**KIRKLEES COUNCIL  
TOWN AND COUNTRY PLANNING ACT 1990  
HIGHWAYS DEVELOPMENT MANAGEMENT**

**PLANNING REF** 2017/62/93396/E0/NH  
**CATEGORY** Small Major

**PROPOSAL** DEMOLITION OF EXISTING  
INDUSTRIAL BUILDINGS AND  
ERECTION OF 18 APARTMENTS  
WITH ASSOCIATED  
LANDSCAPINGWORKS TO FORM  
VEHICULAR PARKING

**LOCATION** VALE WORKS  
25 MORLEY LANE  
MILNSBRIDGE  
HUDDERSFIELD  
HD3 4NS

DRAWING TITLE: PROPOSED DRAWINGS DIAGRAM: VISIBILITY SPLAY

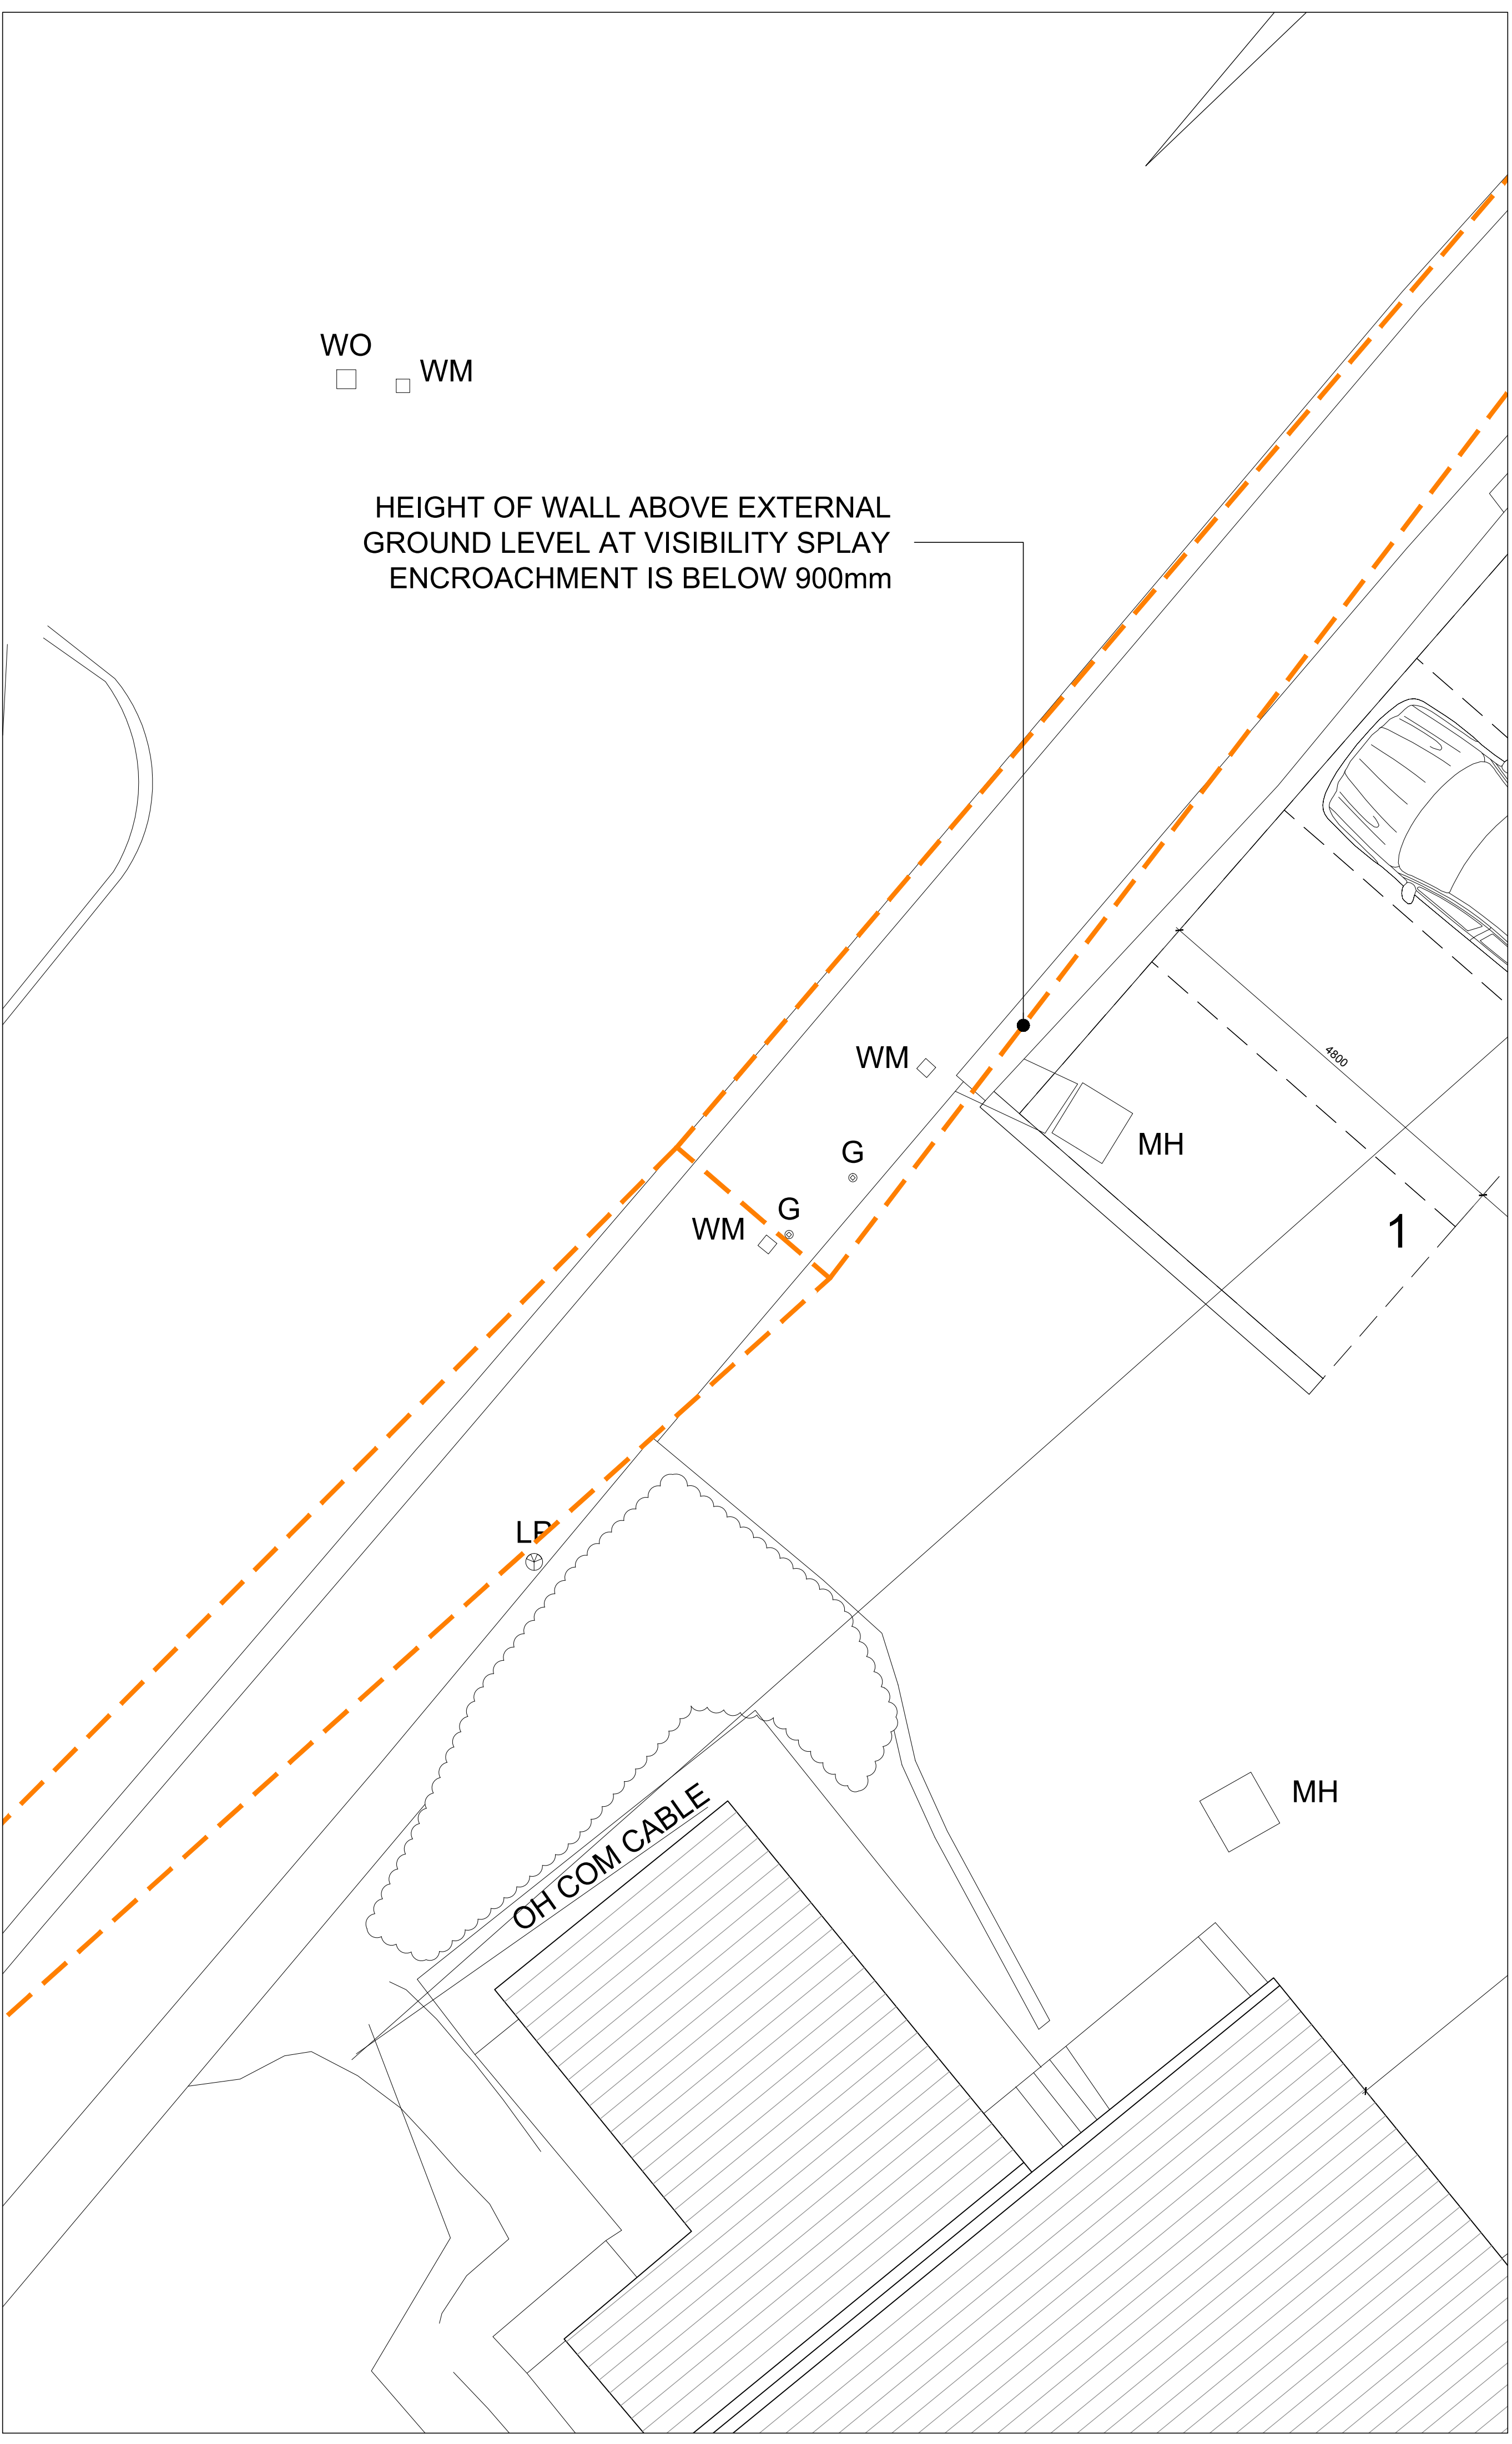
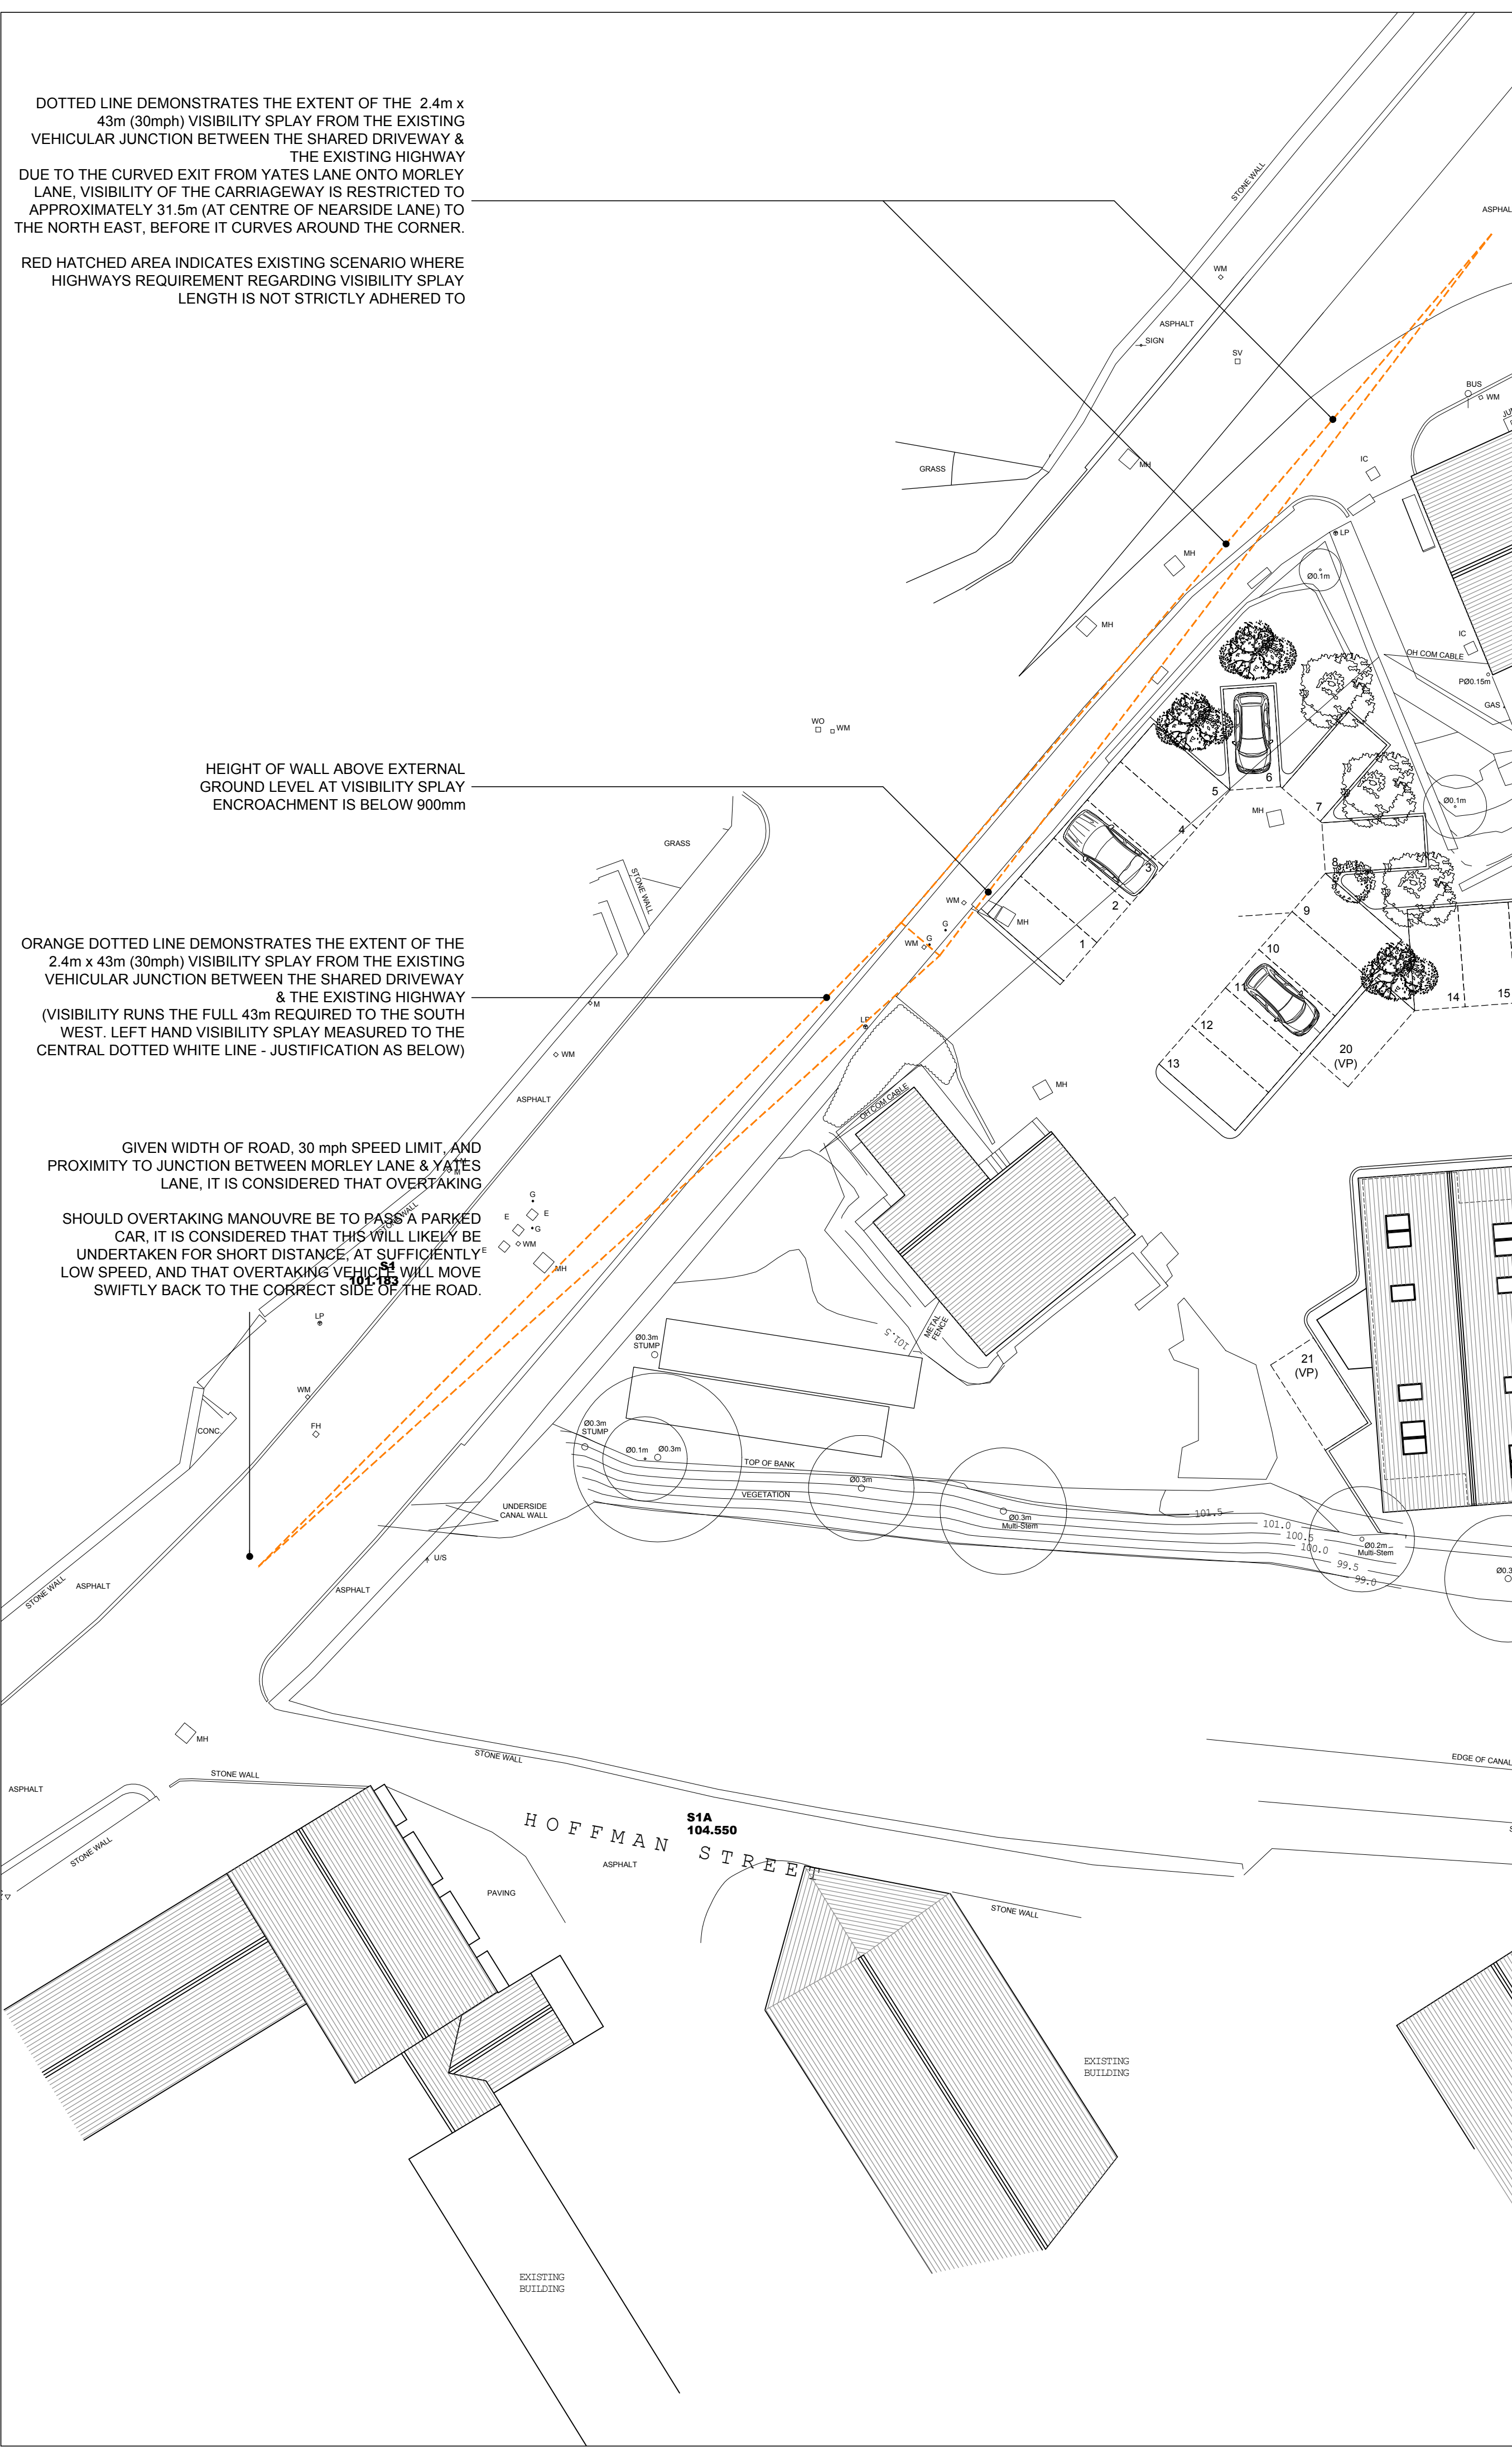
Sightlines have been demonstrated at the site access of 2.4m x 43m in both directions.
